**Subject:** Rezoning Petition Review

**Rezoning Petition #:** 21-021

**Location of Property:** Approximately 27.65 acres located on the north side of State Street, southwest of Rozzelles Ferry Rd and east of Tuckaseegee Rd.

SHEET NUMBER **RZ-01**CITY OF CHARLOTTE

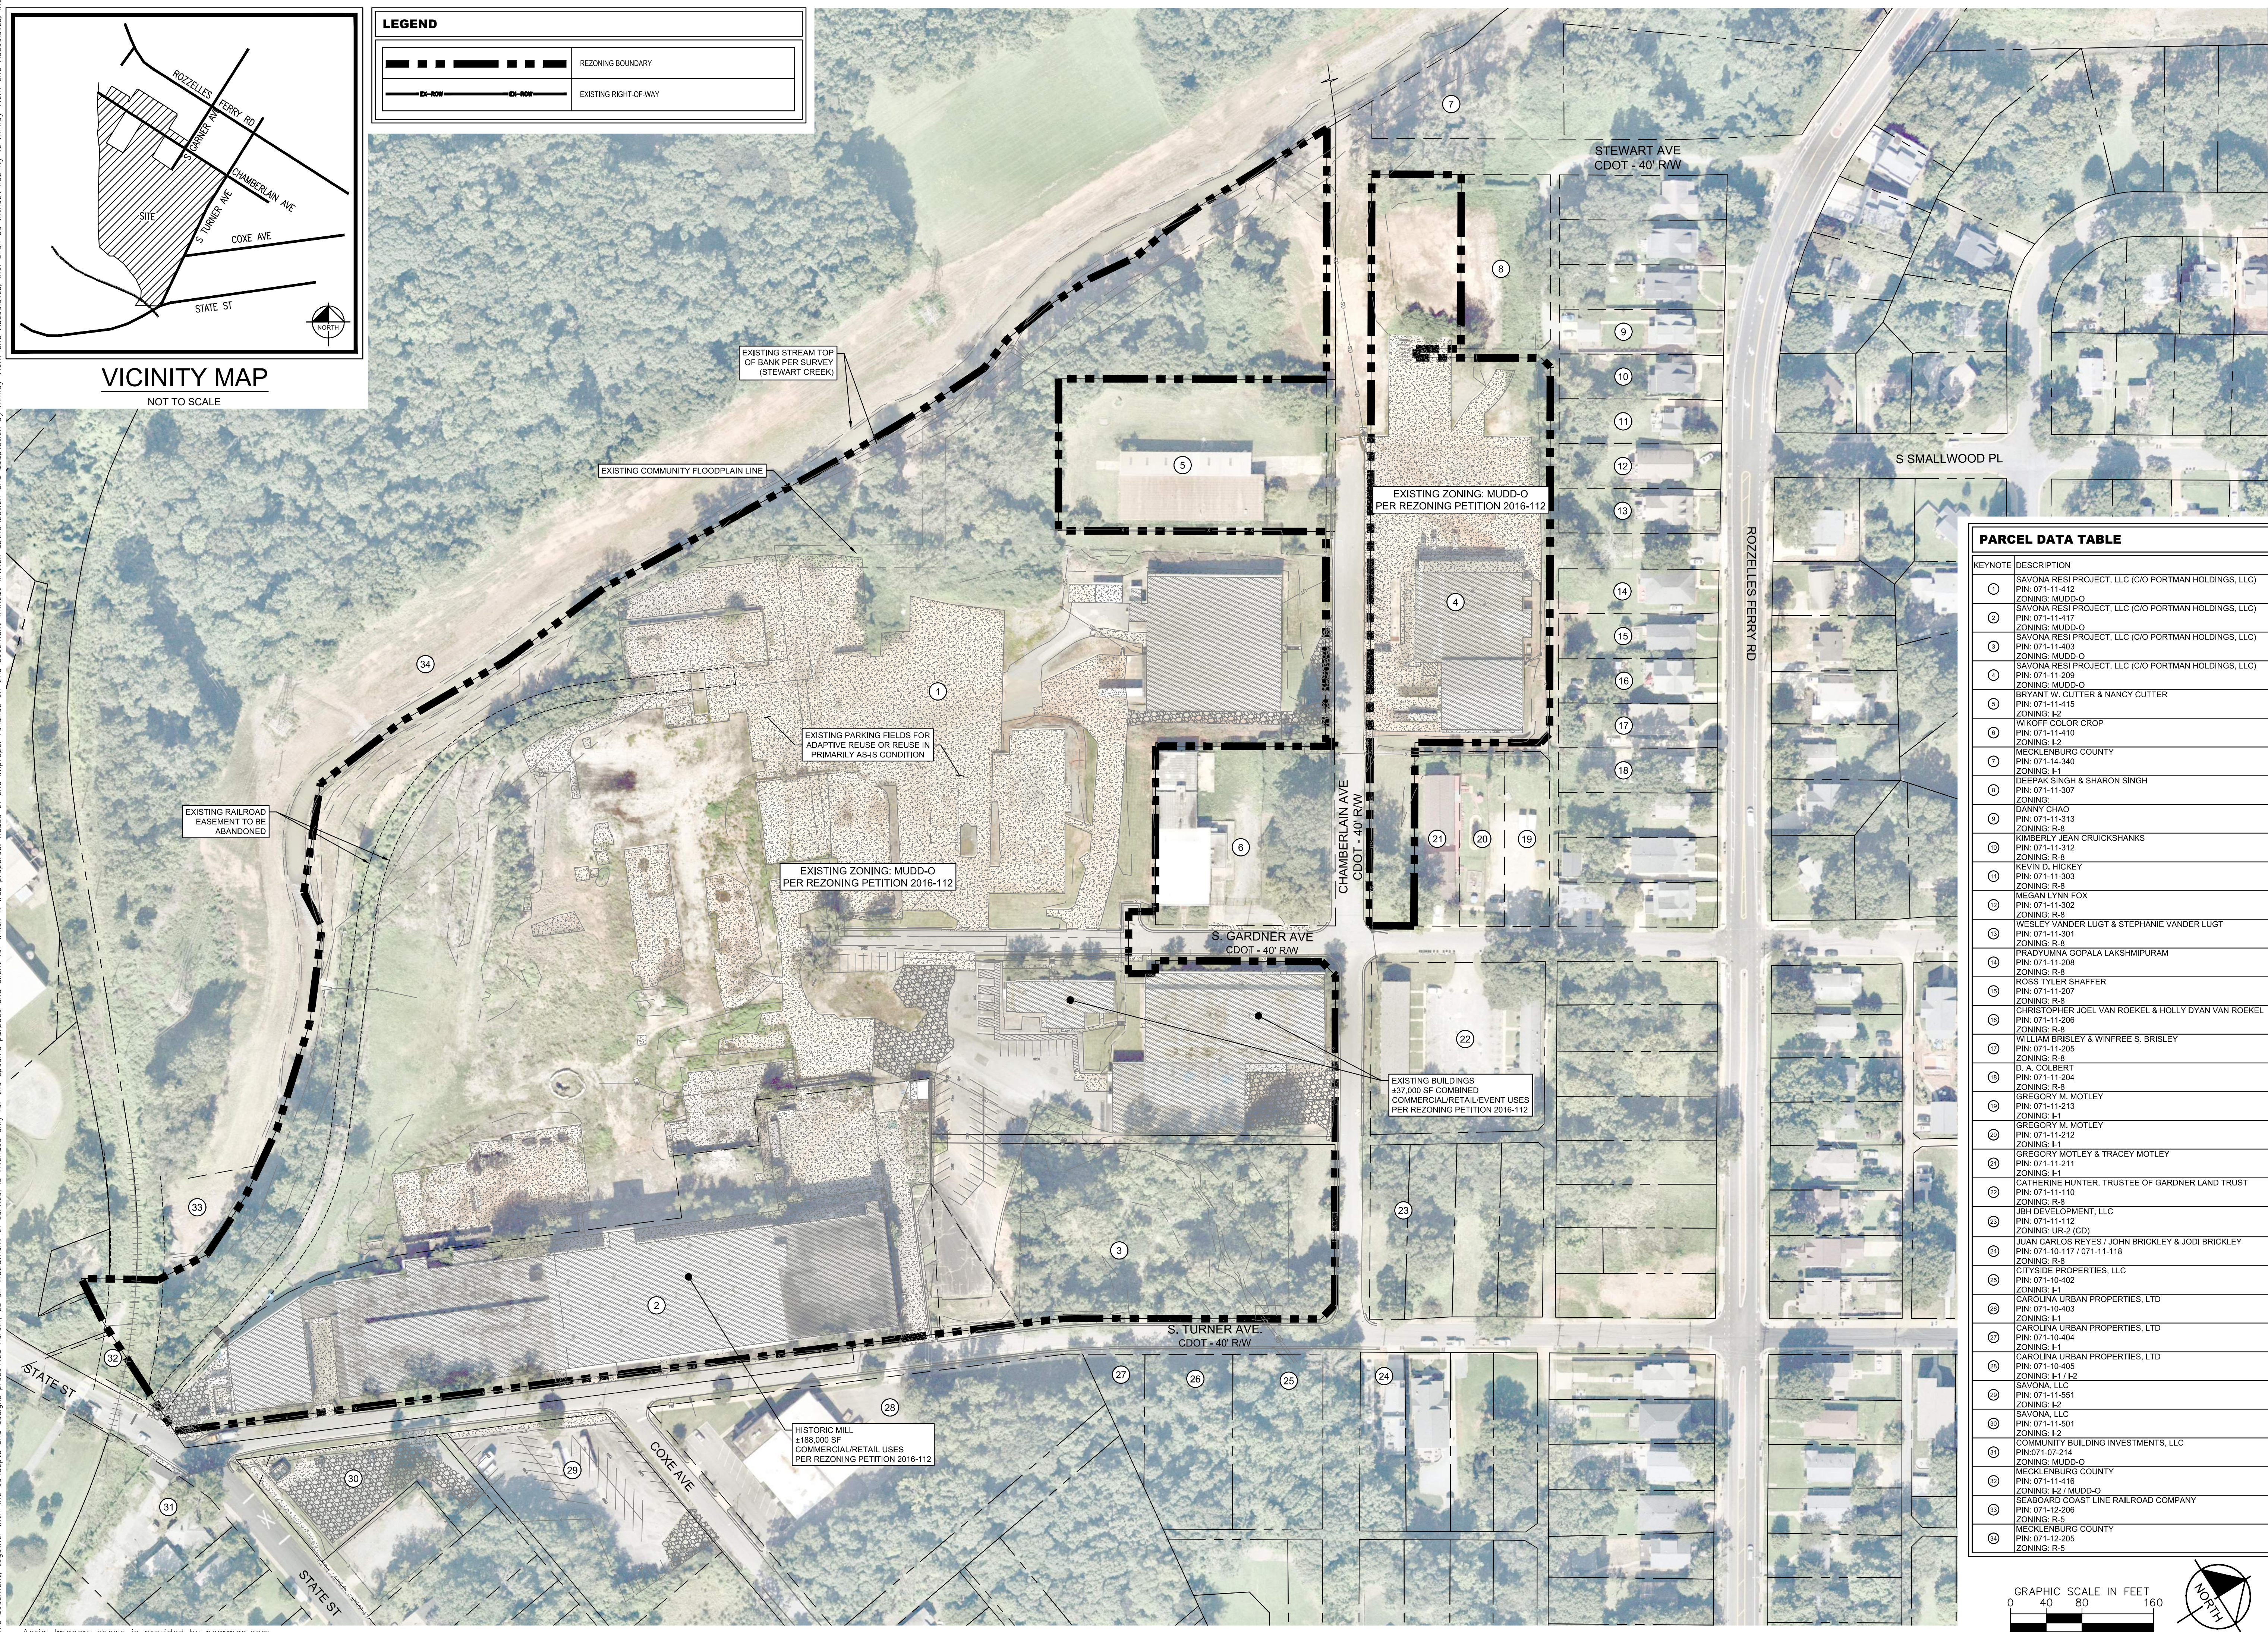
The rezoning plan sheet indicates a proposed location for storm water management. Please include the following notes on the plan sheet under "Environmental Features": *The location, size, and type of storm water management systems depicted on the Rezoning Plan are subject to review and approval as part of the full development plan submittal and are not implicitly approved with this rezoning. Adjustments may be necessary in order to accommodate actual storm water treatment requirements and natural site discharge points.*

Please include the following note under "Environmental Features": *Development within the SWIM/PCSO Buffer shall be coordinated with and subject to approval by Charlotte-Mecklenburg Storm Water Services and mitigated if required by City ordinance.*

Please note Charlotte-Mecklenburg Storm Water Services (CMSWS) has a Storm Drainage Easement (SDE) of varying width over this pipe as recorded in map book 13341 page 19. No buildings or structures are permitted over and across this easement.
